From: Simon Davis
Sent: 27 October 2014 09:25
To: Planning.Responses
Subject: FW: 65b Gravits Lane...land adj... BR/208/14/PL

From: Anita Fletcher [REDACTED]
Sent: 24 October 2014 18:08
To: Simon Davis
Subject: 65b Gravits Lane...land adj... BR/208/14/PL

REVISED PROPOSED PLANS AND ELEVATIONS
FOR LAND ADJACENT TO 65B GRAVITS LANE

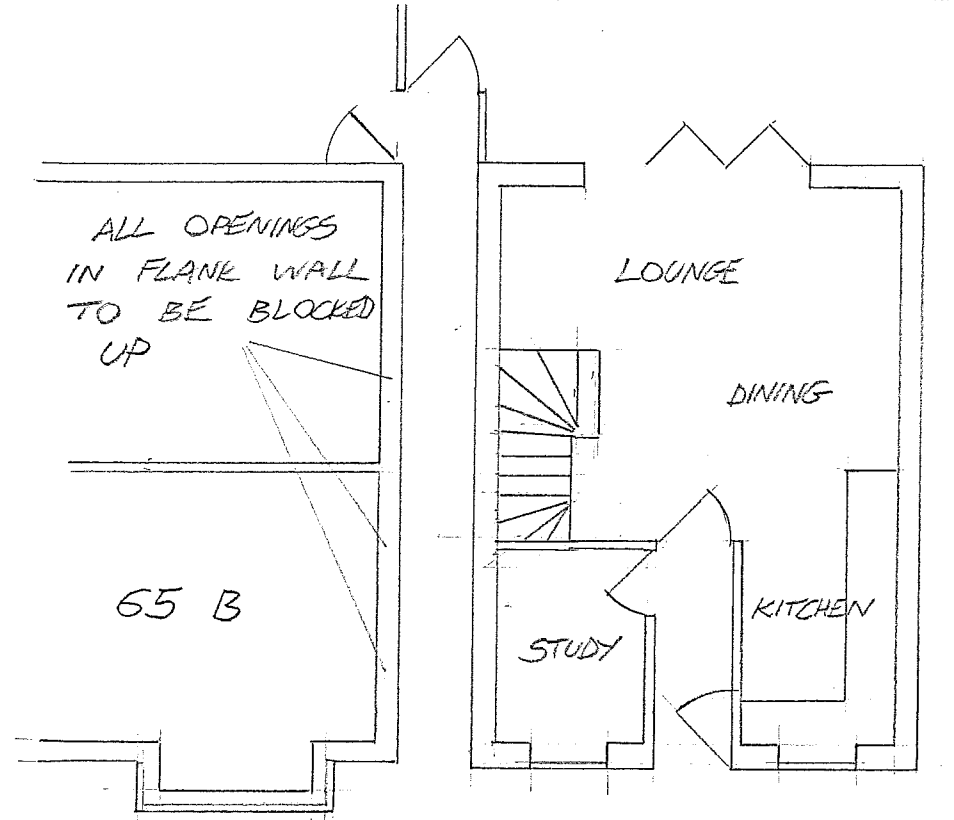
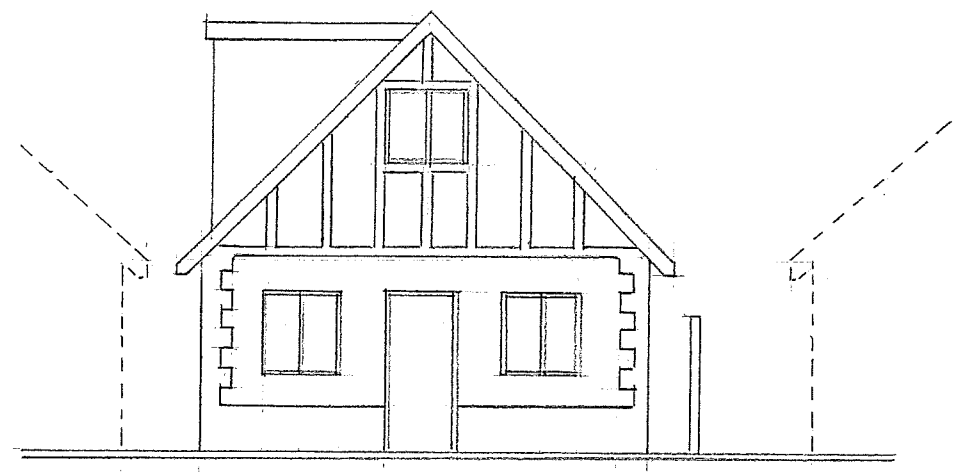
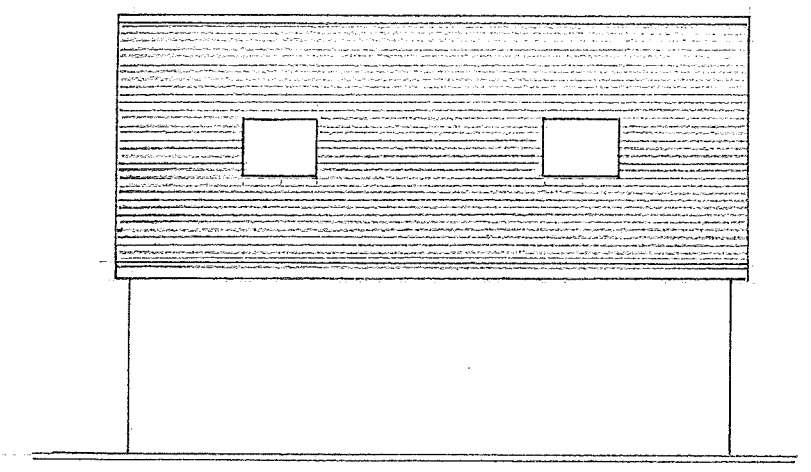
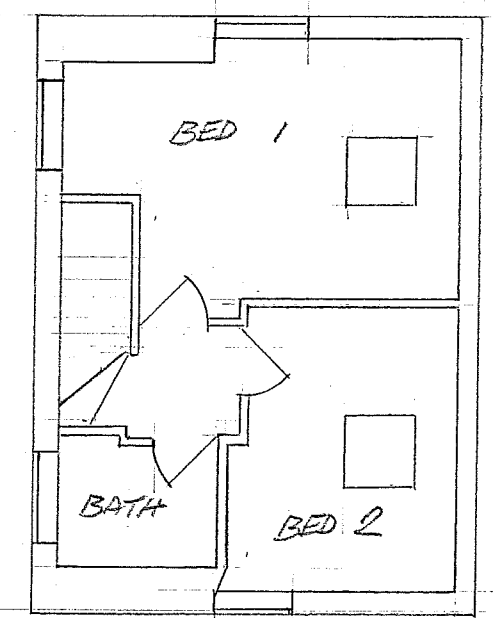
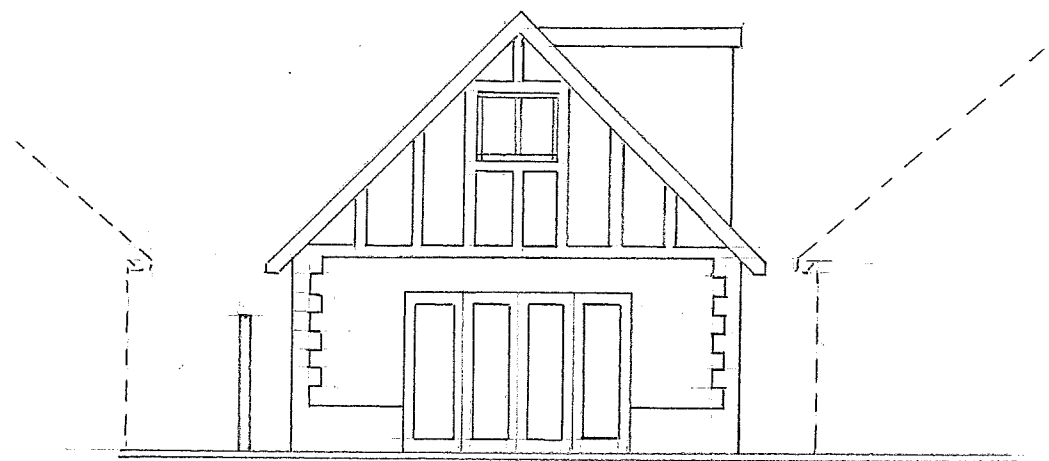
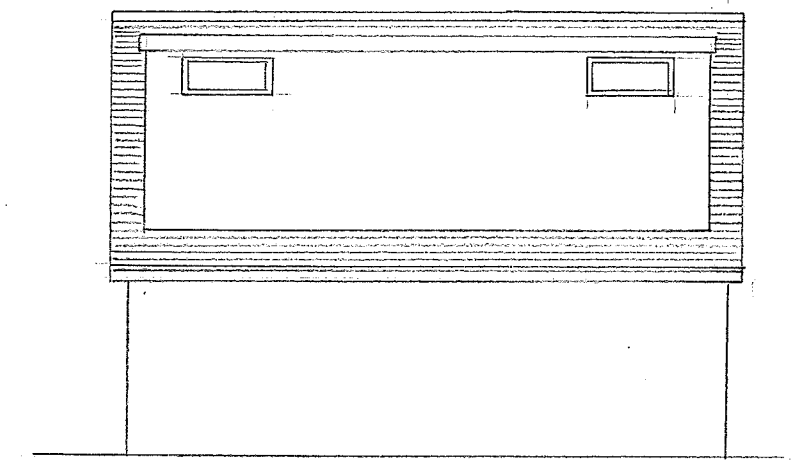
He has been beyond rude to us and the neighbourhood and why a whole neighbourhood is up against this build. My day to day life for lighting will be destroyed, in which I will have to use lighting at all times. I'm disgusted that the plans got agreed last time and we were told it was just a kitchen. I use my kitchen as im at home all day as im a housewife and its important I have light in it. I dont want to be put in the dark for having this house built. It would perhaps be nice if you came and viewed within my home, so you can see how this would effect us. He has now changed the plans taking land on 65b so that he can have enough garden to come to your terms. No one seems to care what myself or the neighbourhood say, or even the Bognor Regis Council saying that they object that the land is over crowded.

Also, would like to point out to yourself that he built a dormer that looks out of place within the street, without permission until he got picked up on it as neighbourhood complained and a this decision has now been made...refused. This new build has the same large dormer on it, being squashed between two houses. Beyond me that anyone can still think this is good to happen, when not yards up the road, (about 6 houses), that a large piece of land keeps getting refused for house builds, but a small piece can be approved. Its not as if there are not any new builds going on, just the street behind us that was the school has just had a whole new neighbourhood developed. I really do think we have enough houses in the area.
